Planning Officer: Mr D Easton

Planning Application Ref: Y/127/21/RES

Location: Land at Bilsham Road, Yapton

Description of works: Approval of reserved matters (appearance, landscaping, layout, and scale) following the grant of Y/91/17/OUT for 250 No dwellings with associated parking, road/footway/cycleway provision, open space, landscaping, surface water attenuation & ancillary works (resubmission following Y/152/20/RES). this site is not CIL Liable as in Yapton Strategic Site

P:19-326 - Bilsham Road, Yorton RMTech\Acad\Drawings\000 Series\19-326-006 Preliminary Engineering Layout Sheet 1 of 2.dwg

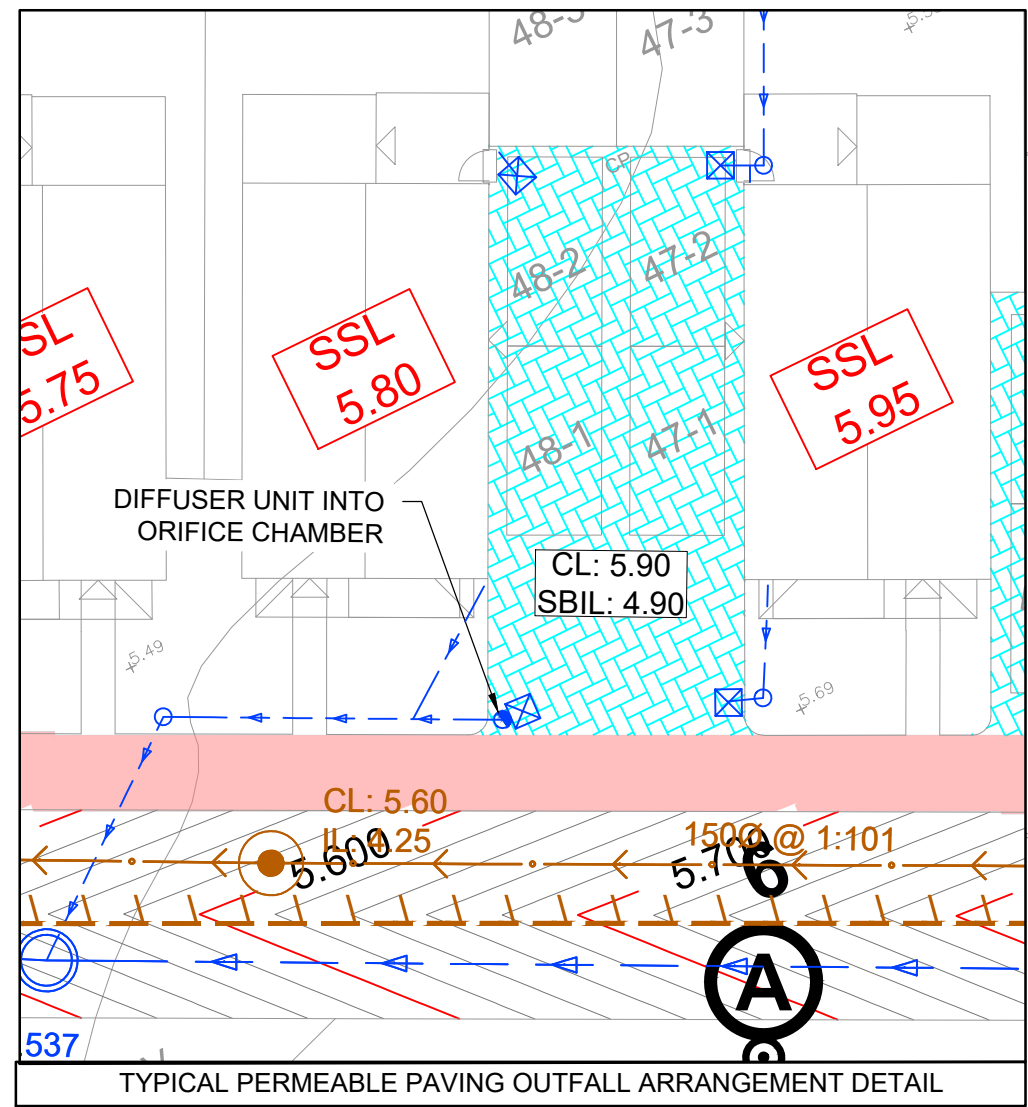
- Similarly, they have referenced Preliminary Engineering Layout Sheets 1 & 2 and appear to have incorporated key elements within their own Tree Protection Plan to reveal the impact from/viability of, surface water drainage proposals.

- Our Drainage Engineer should be provided with latest information (including Tree Protection Plan) and re-consulted. Obvious areas of significant conflict with SUDs features and their buffer/easement:

- i) T4 – Absence of buffer zone between RPA and attenuation basin 3.
 - ii) T5 – Attenuation basin 3 within RPA. Drain installation bisects RPA.
 - iii) T8 – Potential intrusion from culvert into veteran tree buffer zone (extent to be determined).
